Additional Responses to Change Application – Boston Borough Council

Our ref no: B/22/0271

Targeted Consult on changed to DCO to BBC for the proposed Heckington Fen Solar Energy Park.

HECK-SP22/HECK-AFP011
Compensatory Tree Planting

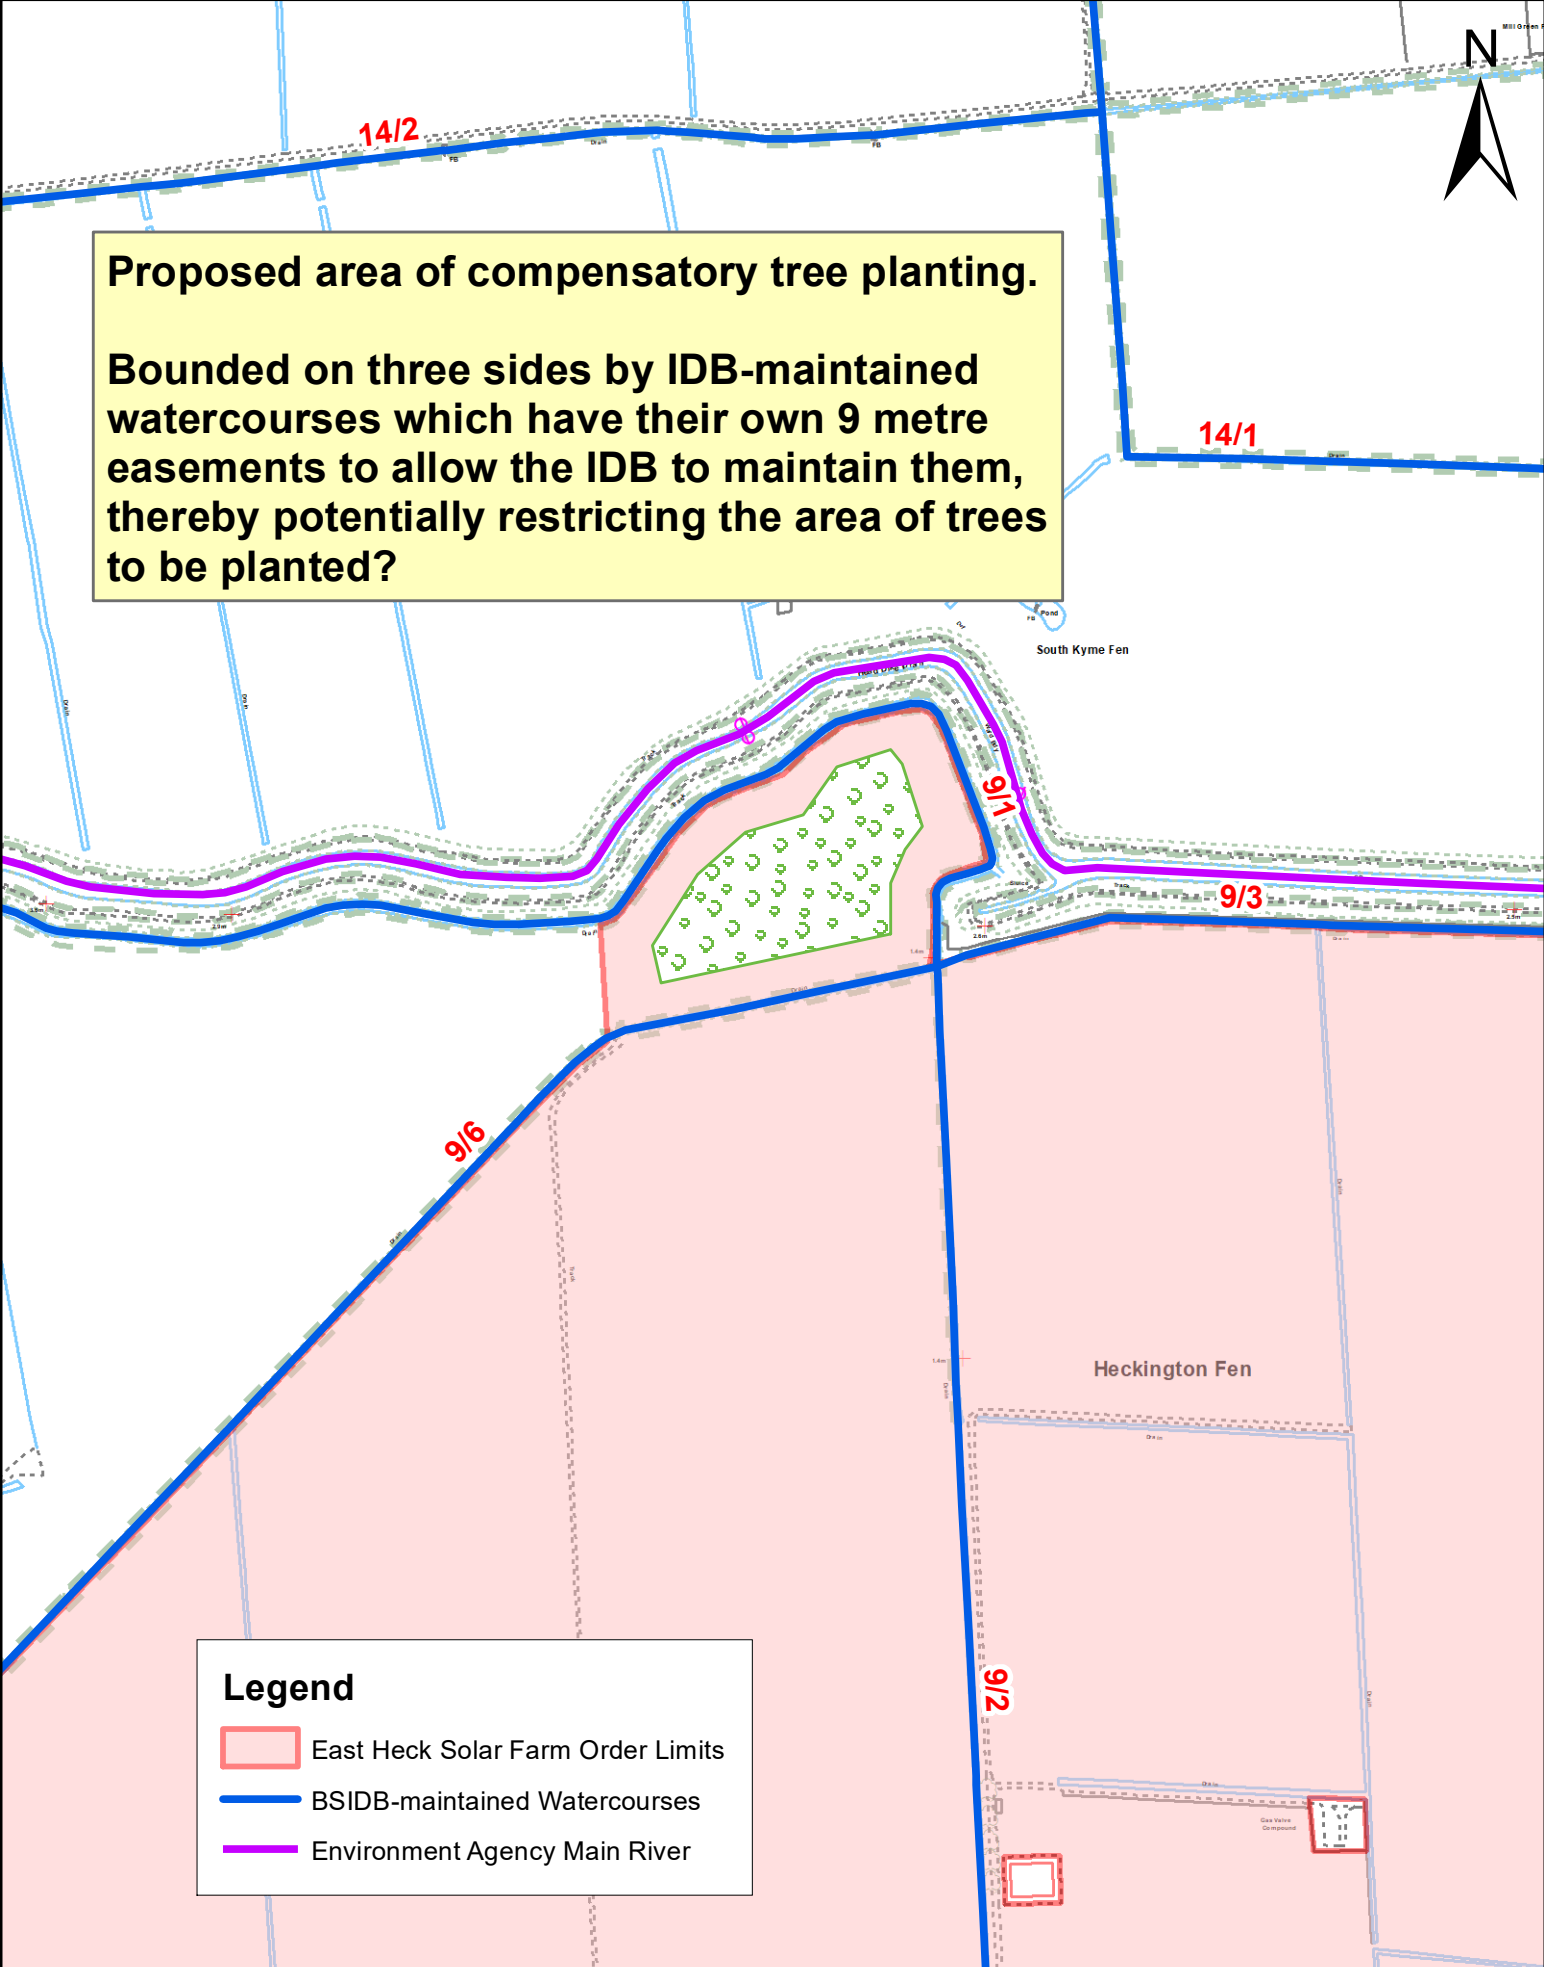
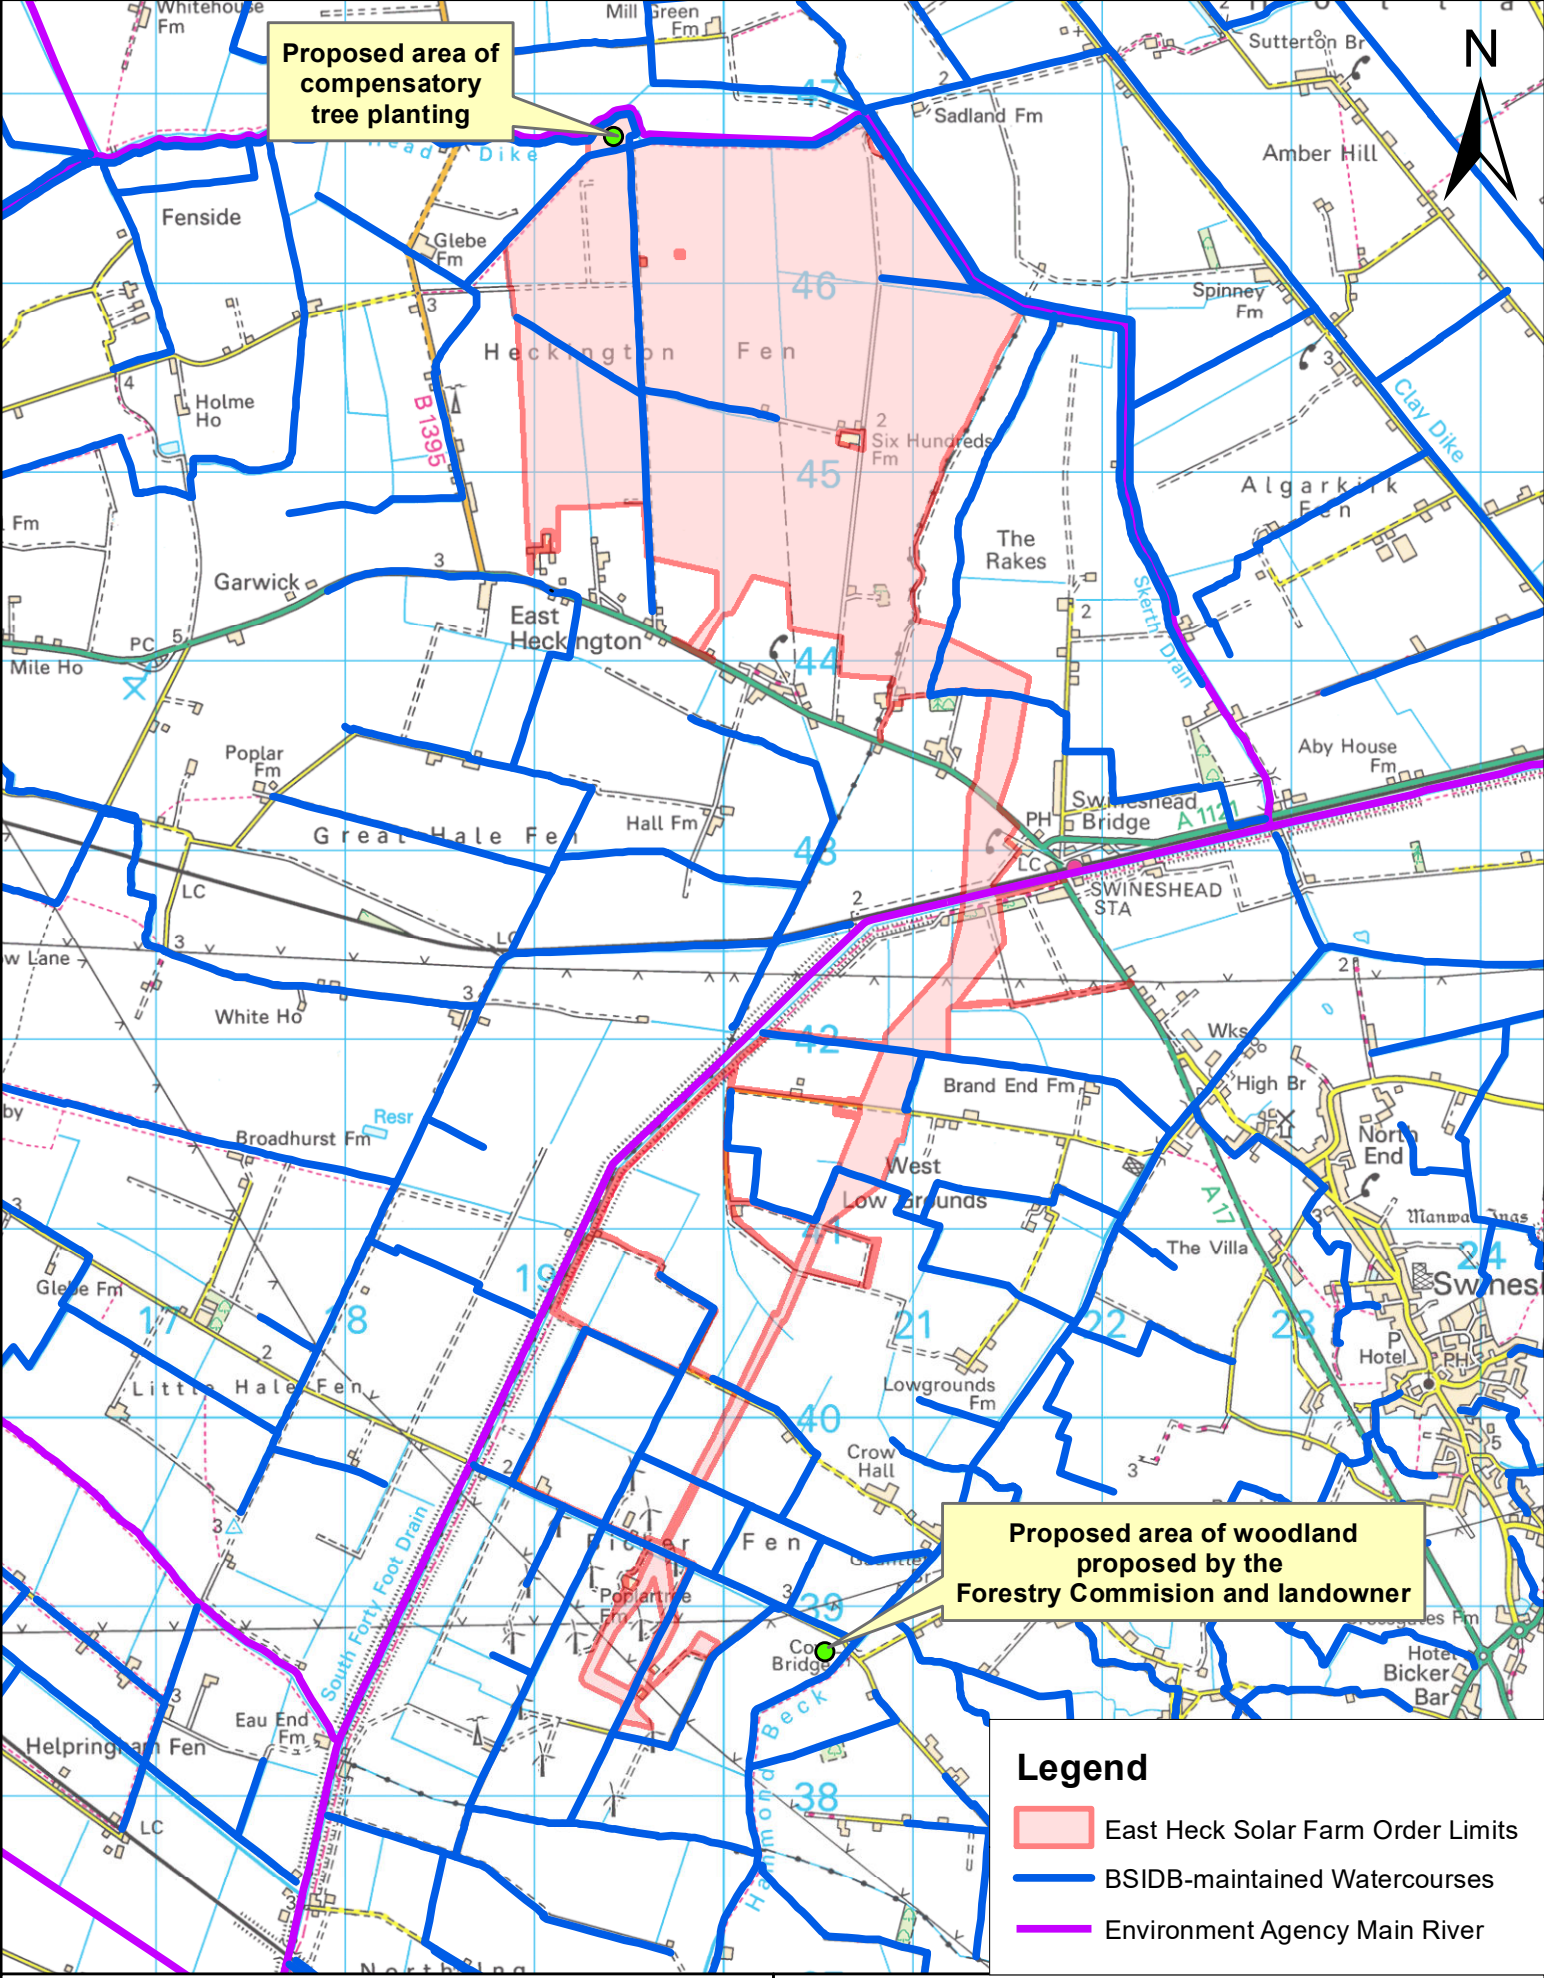
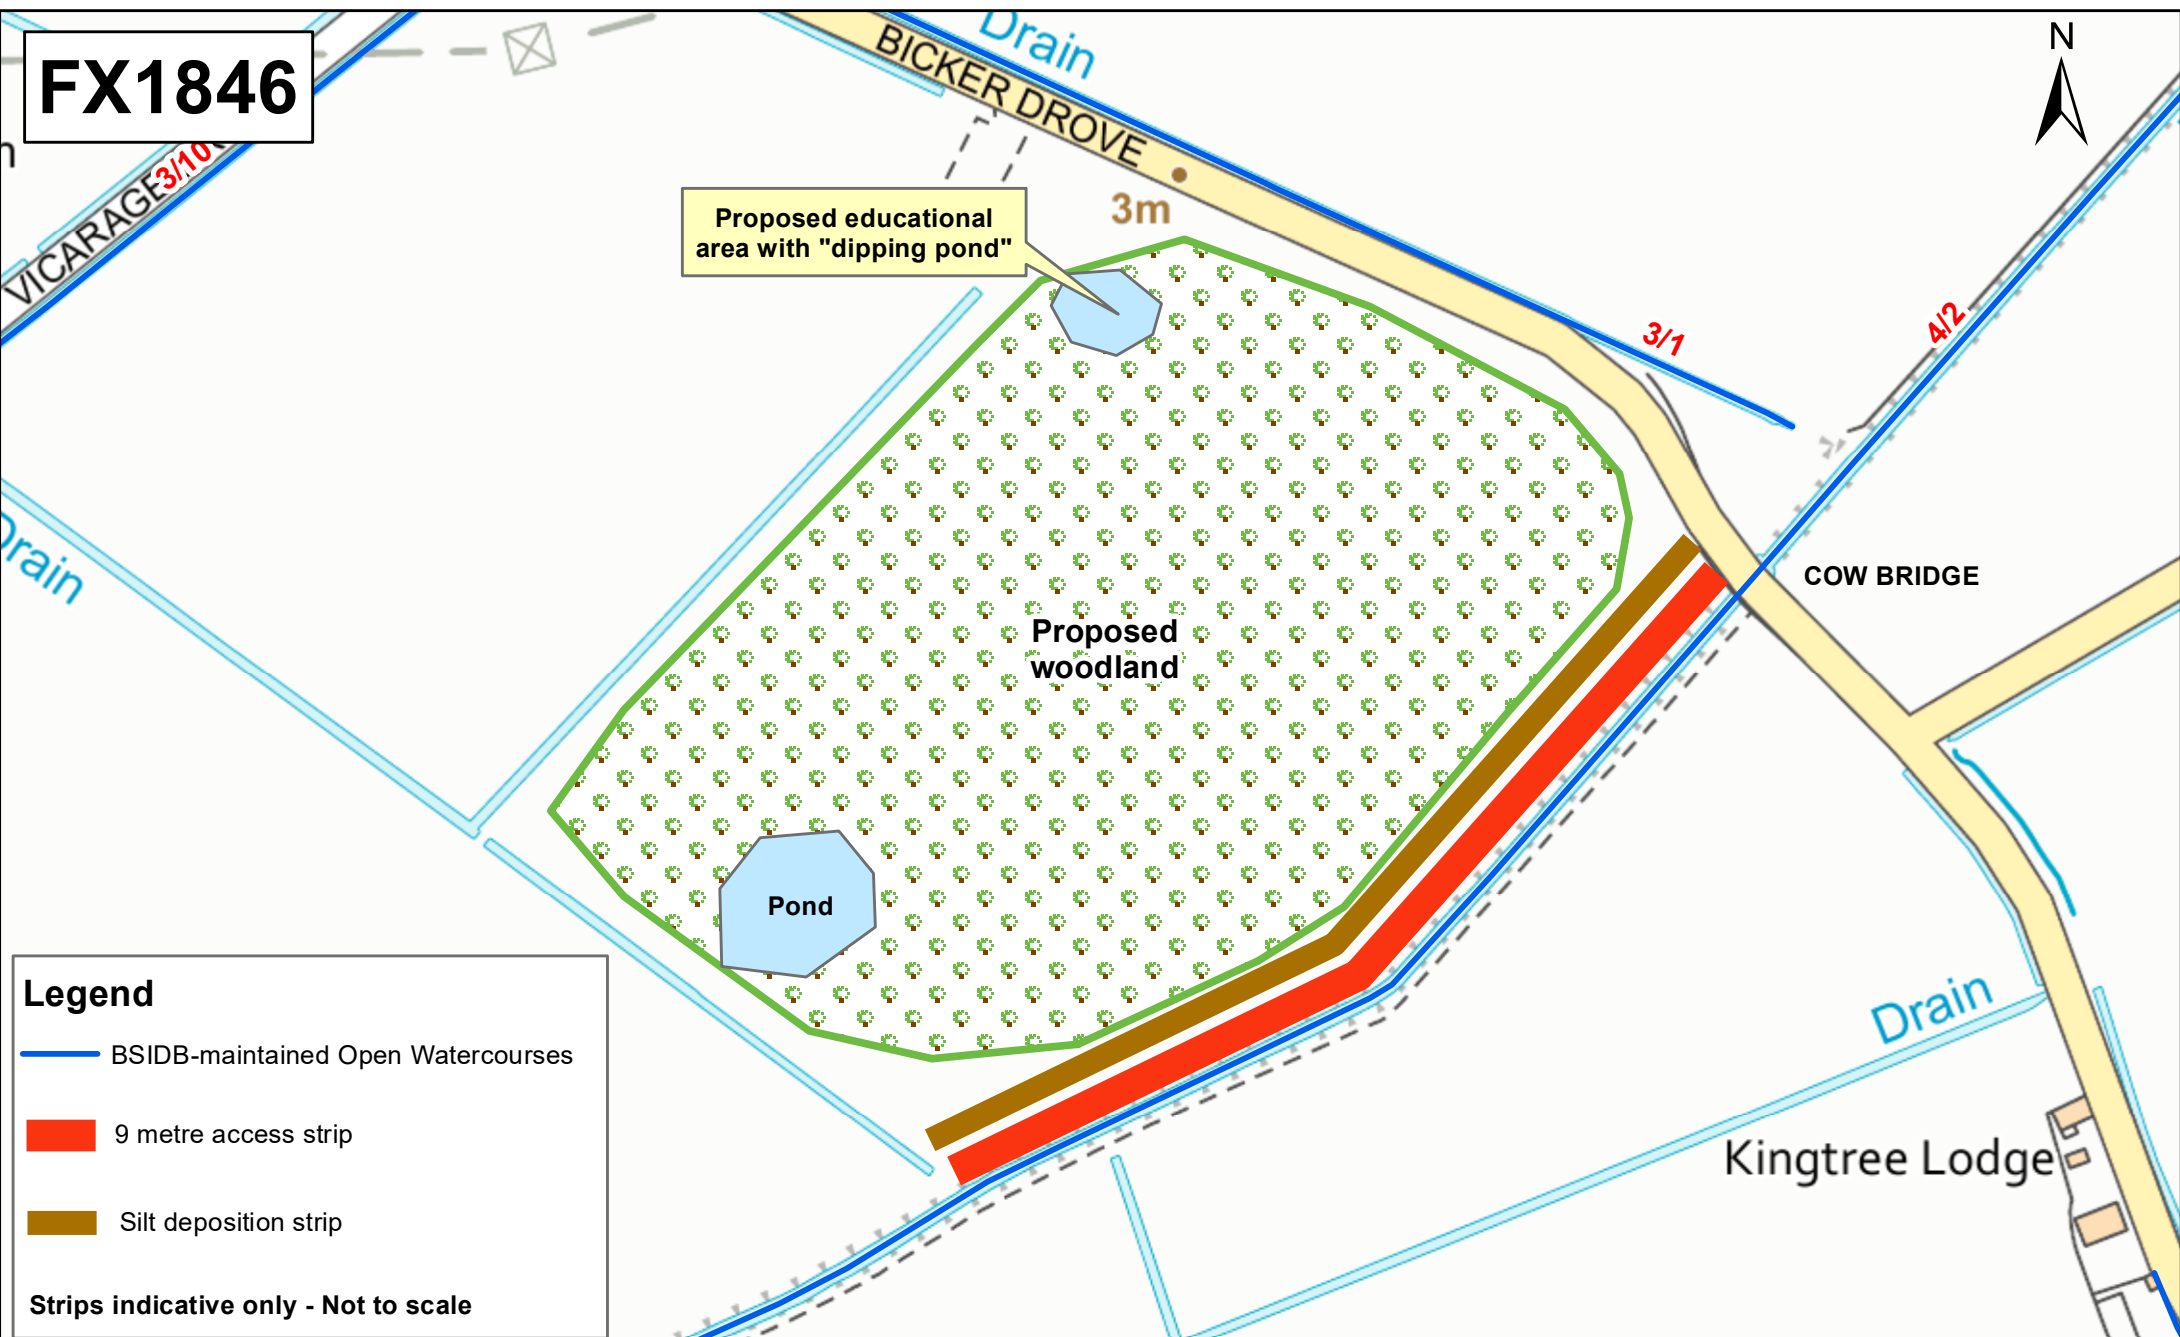
During the Issue Specific Hearing 2 the Black Sluice IDB mentioned that a local land owner intended to plant an area of trees and the Examining Authority requested that details of this were submitted at this Deadline 1. This is an interesting initiative, but the Borough Council points out if this planting was going to happen in any case and the Heckington Fen Solar farm did not require the trees to be felled at the substation, the Borough would have benefited from additional tree planting in any case. As a result of the felling required at the substation, the Boston Borough will remain short of what it could have had in tree coverage.

The Examining Authority will decide if the details of the tree planting scheme and any support the applicant can provide to it are sufficient compensation and whatever mechanism is used to achieve this is suitable.
